Development Facilitation Team (DFT) – Review Comments

Project No: PR-2023-009652 Date:02/12/2025 Agenda Item: #1 Zone Atlas Page: C-10

Request: Subdivision of Land Major for an approximately 19 acre property and Sidewalk Waiver to allow 6-foot sidewalk width in an Urban Center.

Application For: SD-2025-00008 – PRELIMINARY PLAT

**7 PROPOSED TYPICAL SECTION - UNSER BLVD. AT INTERSECTION APPROACH**

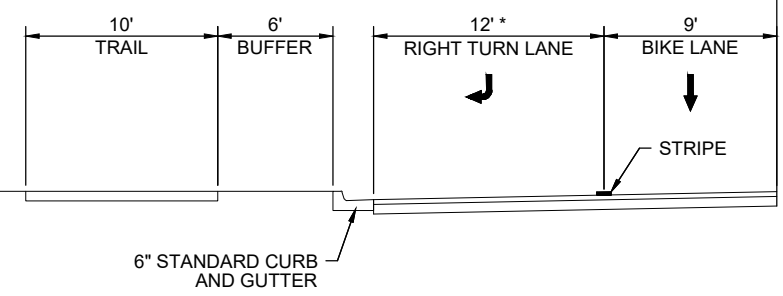
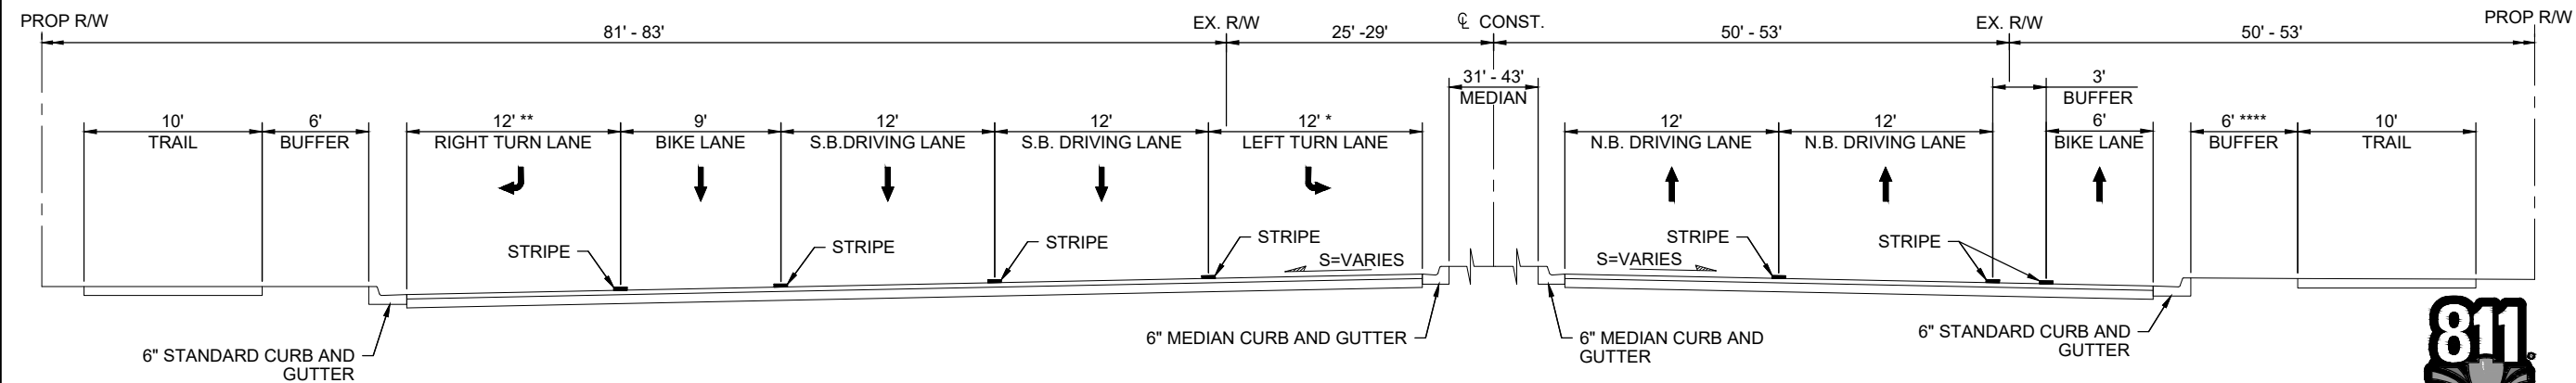
Provide a detail showing where the trail will be accommodated in the ROW along Unser.

**TRACT 1A
A REPLAT OF
THE WESTERLY PORTION OF TRACT 1
SUMMARY PLAT, 68.75 ACRE TRACT
& 66.15 ACRE TRACT
PARADISE HILLS, TOWN OF ALAMEDA GRANT,
CITY OF ALBUQUERQUE, BERNALILLO COUNTY,
NEW MEXICO**

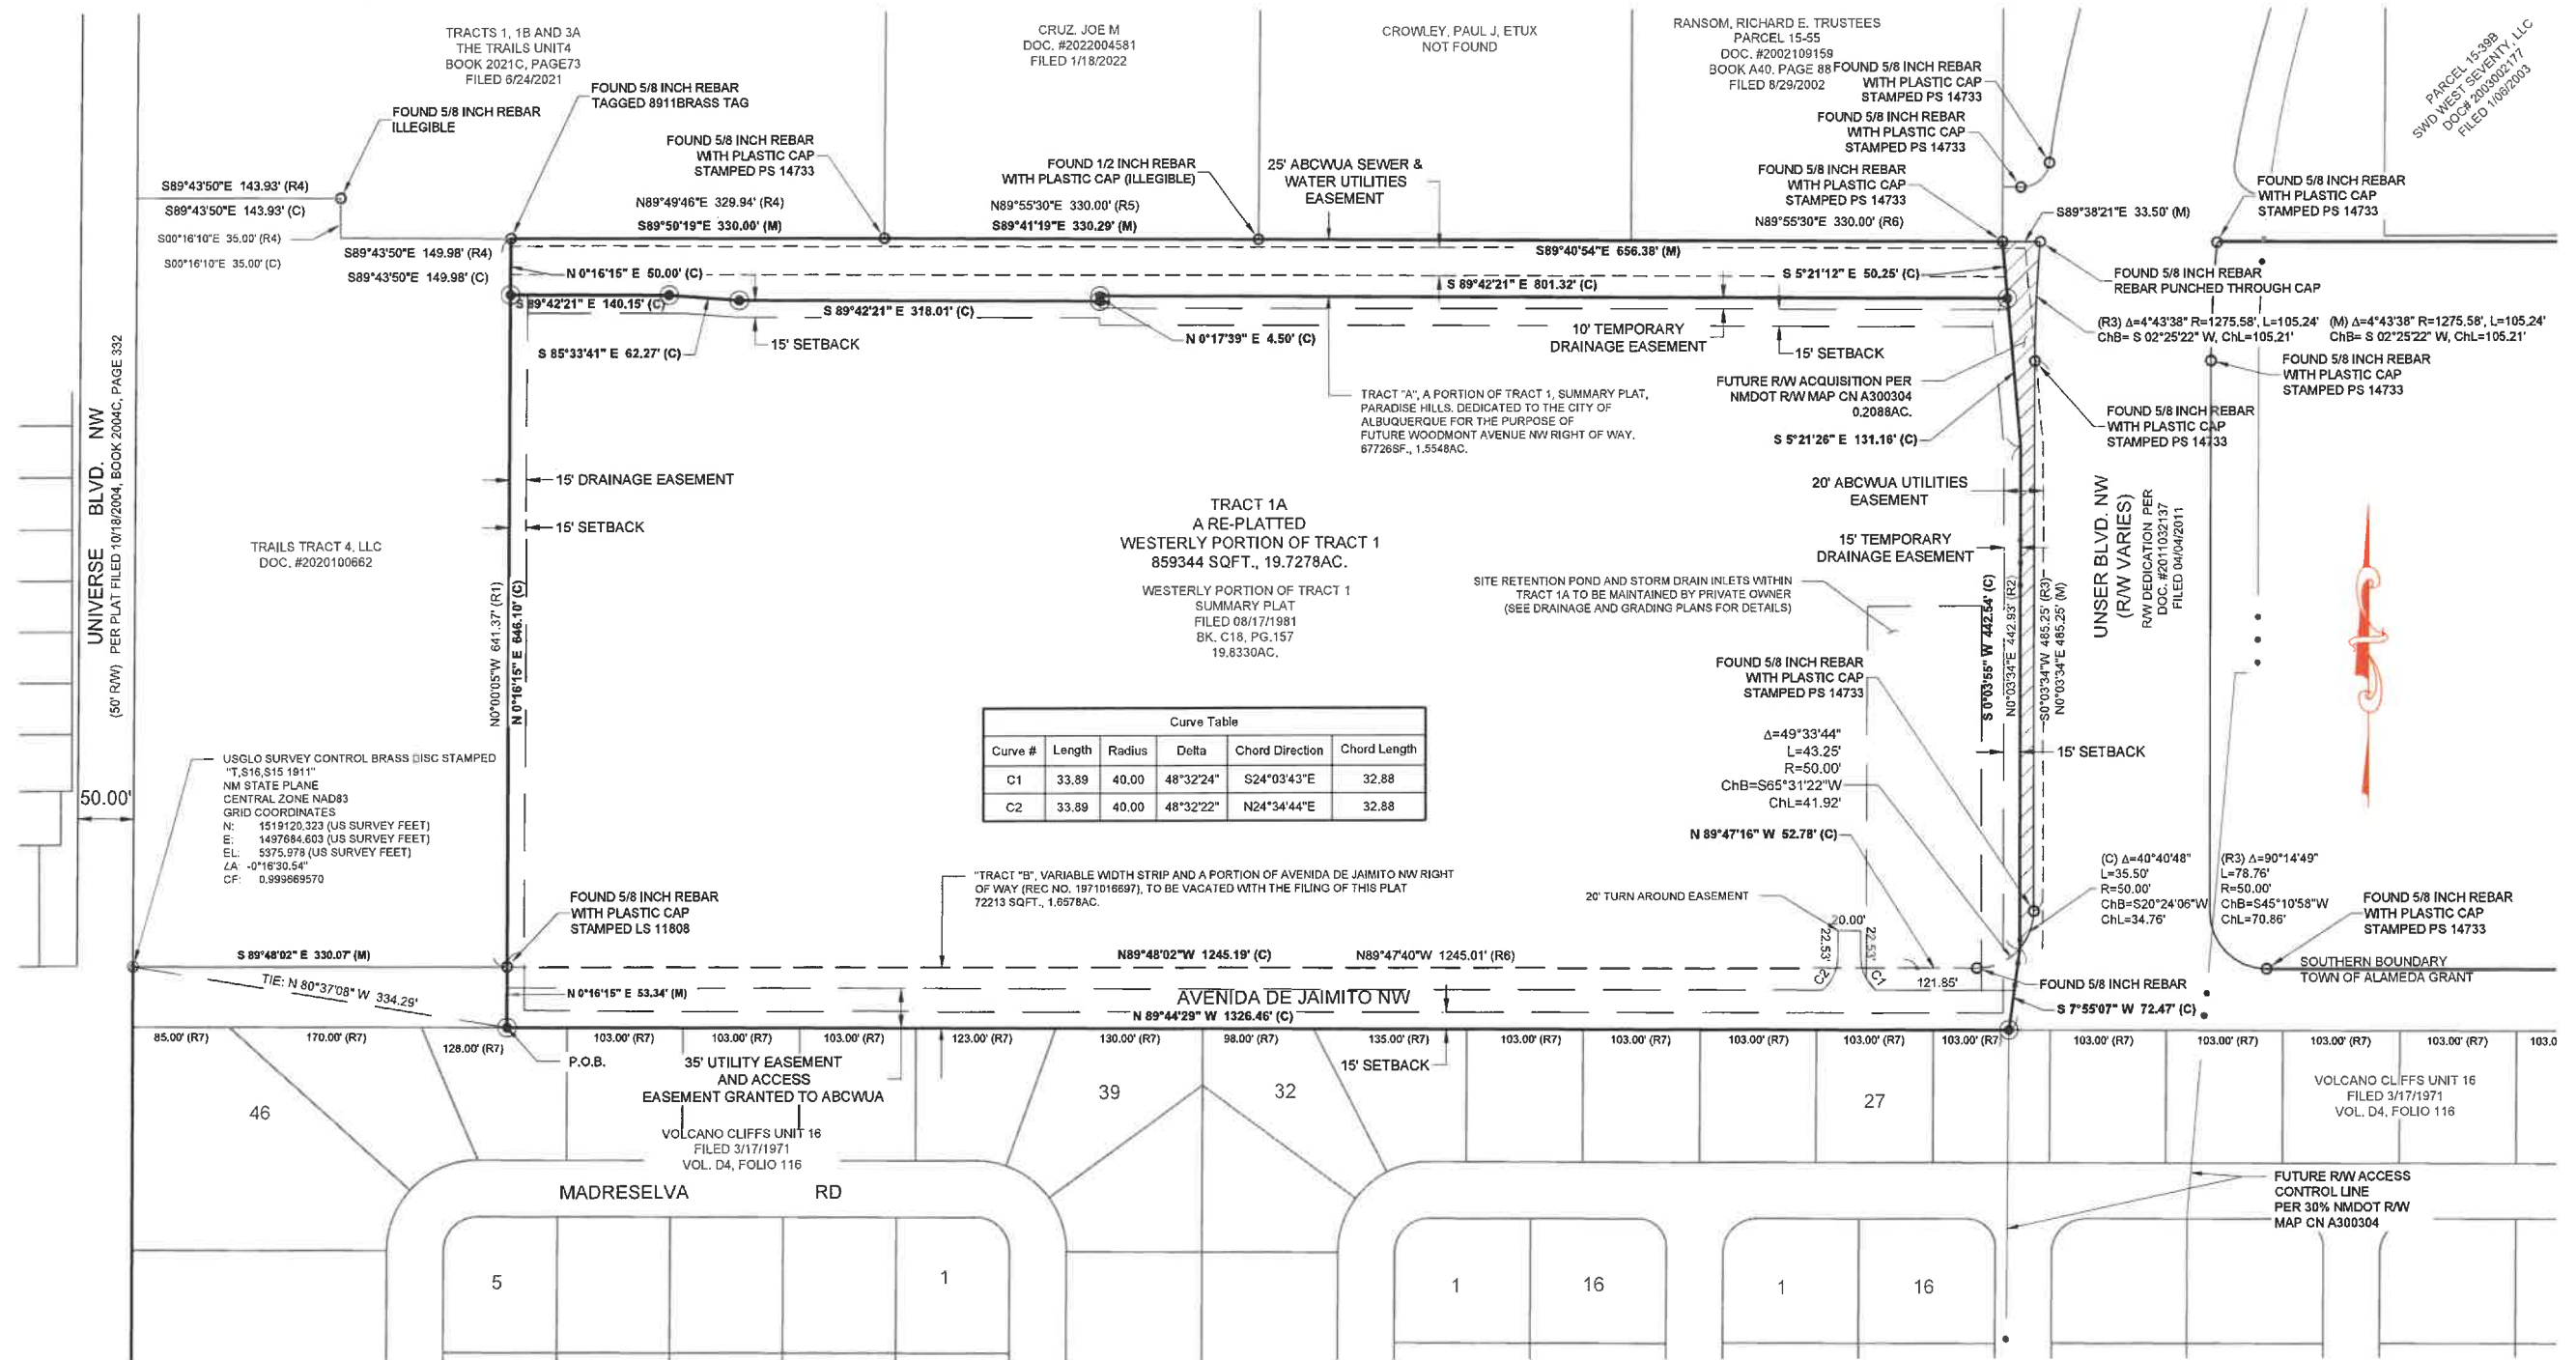
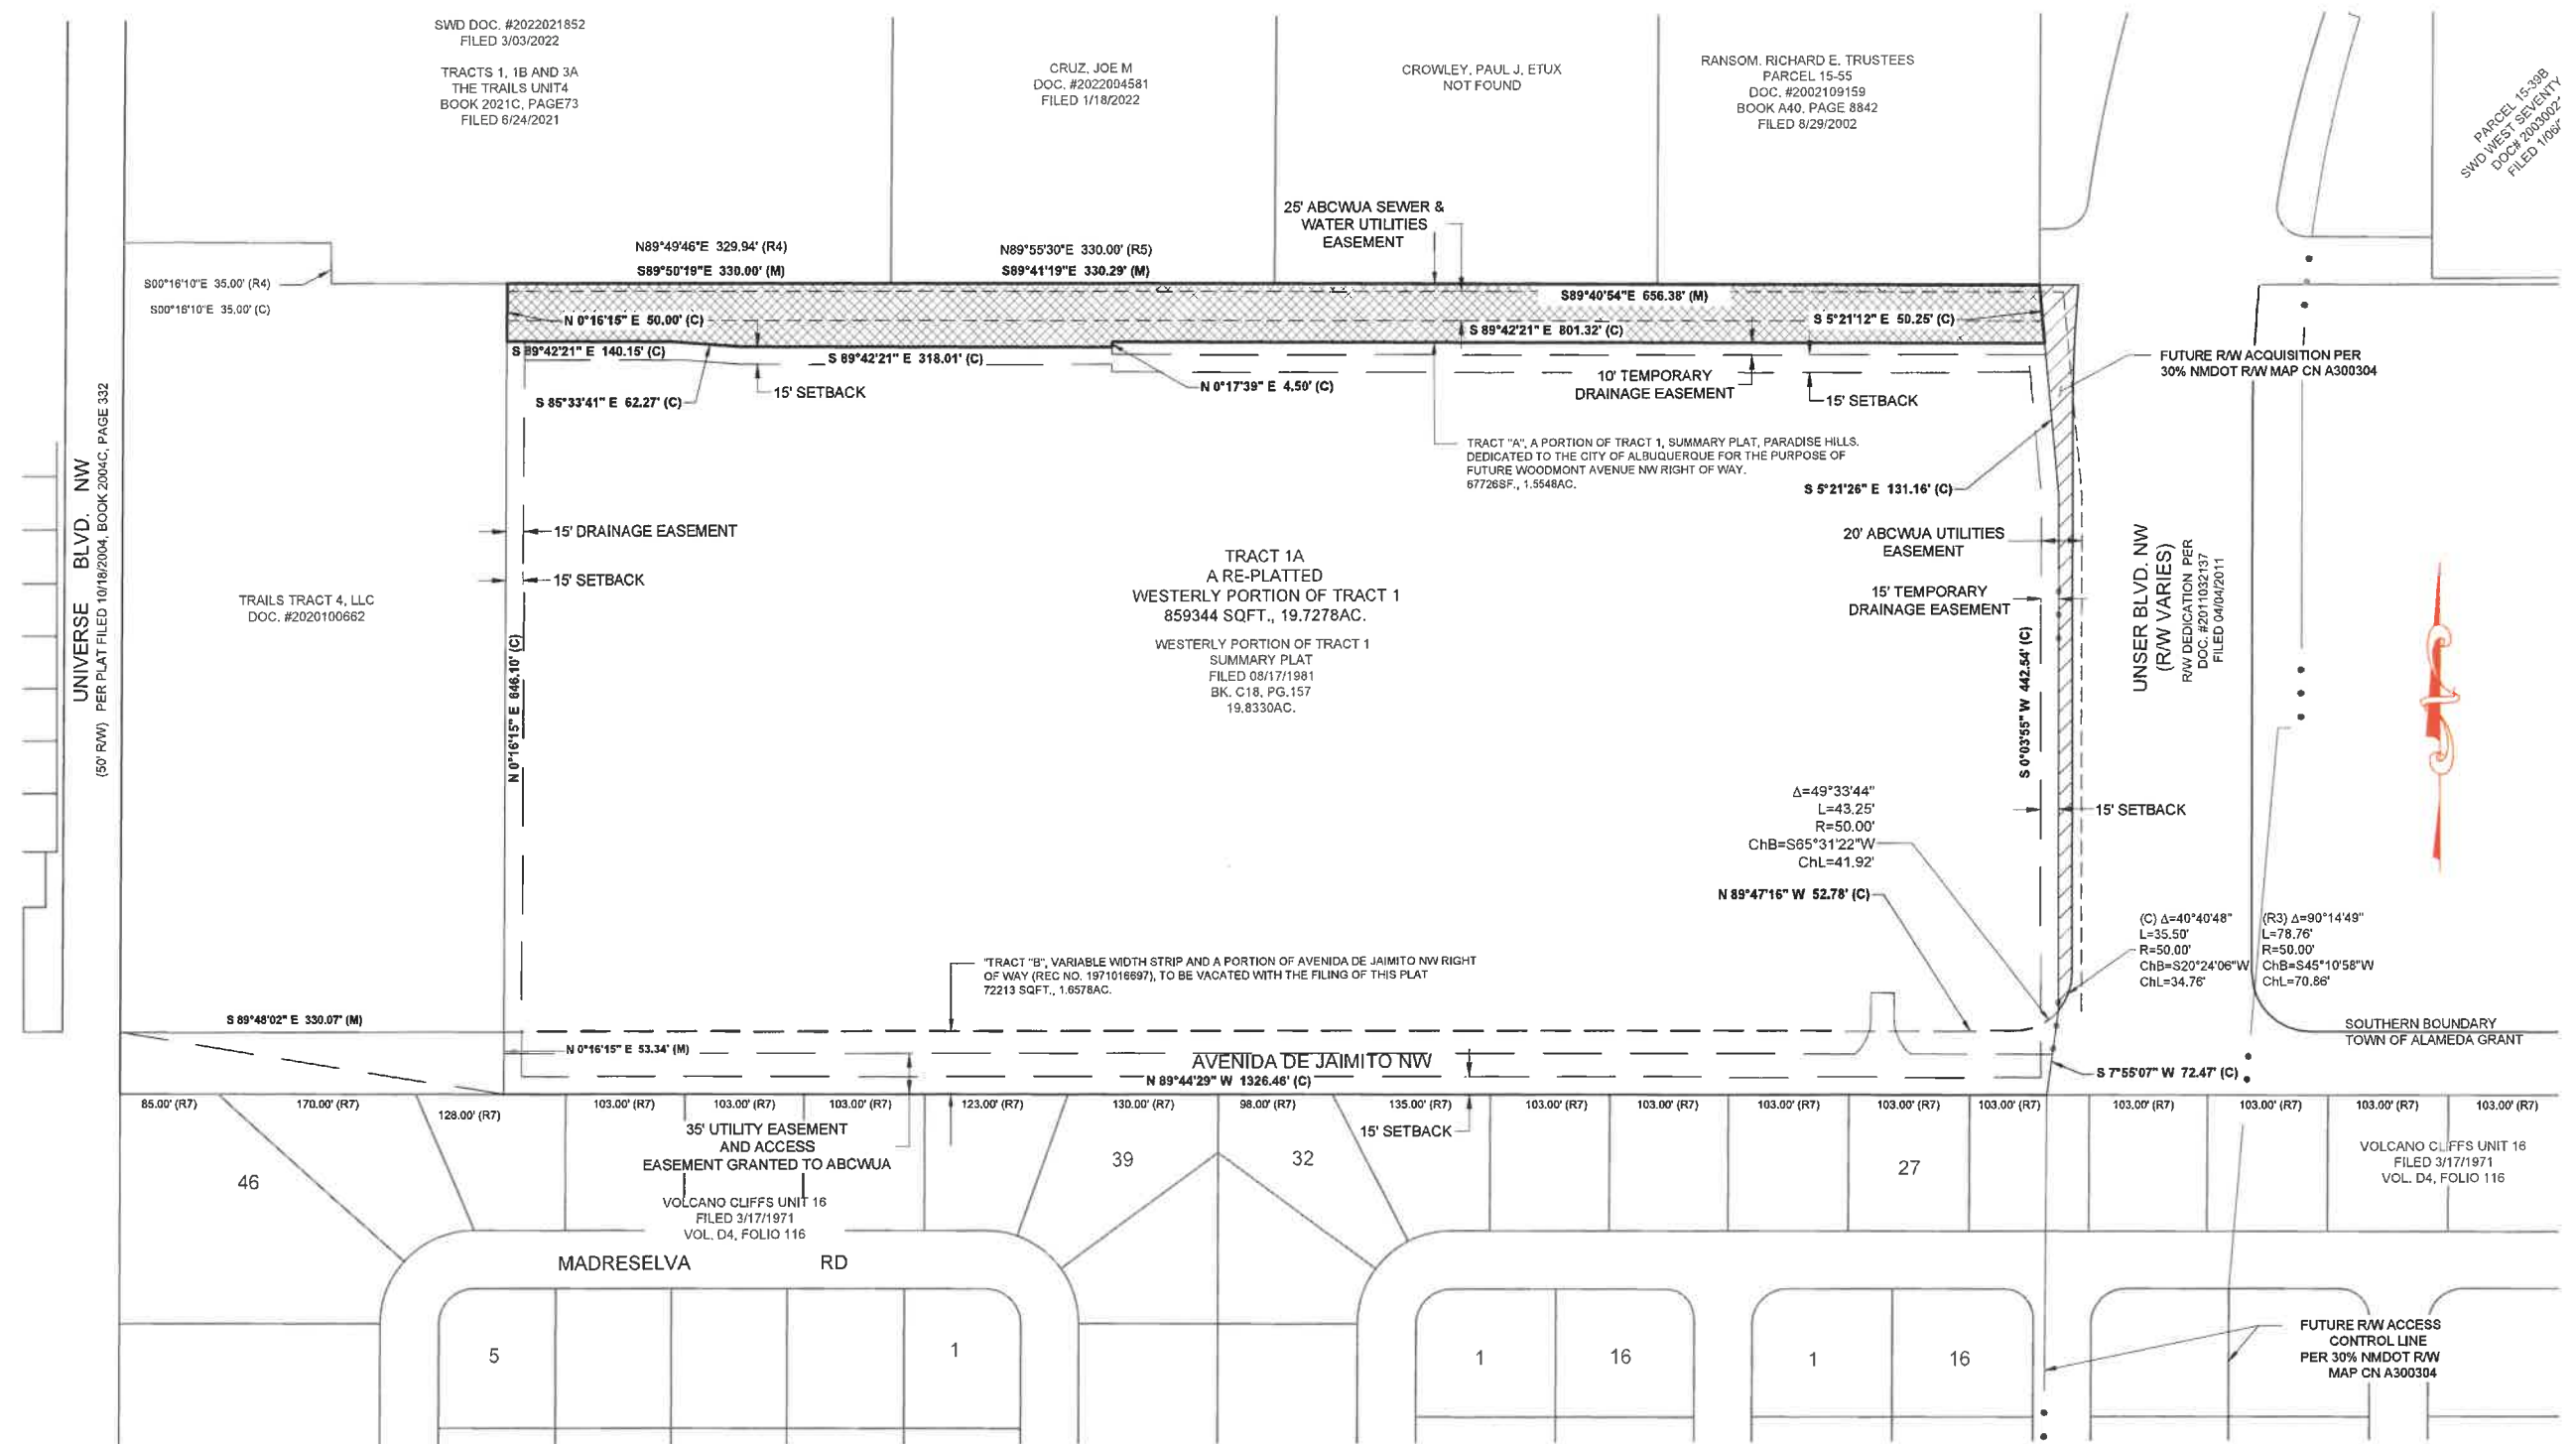
1. Transportation does not support the waiver to sidewalk. The sidewalk in the area of the drainage swale can be widened toward the street as it appears that there is space between the sidewalk and the curb in this area. There is no reason that sidewalk should not be constructed at the full width, especially in the area outside of the vicinity to the swale.
2. Right of way should be adjusted to provide for the widened sidewalk prior to approval of the plat.

The title of the Plat above seems vague, provide confirmation that the title above is what it’s intended to be.
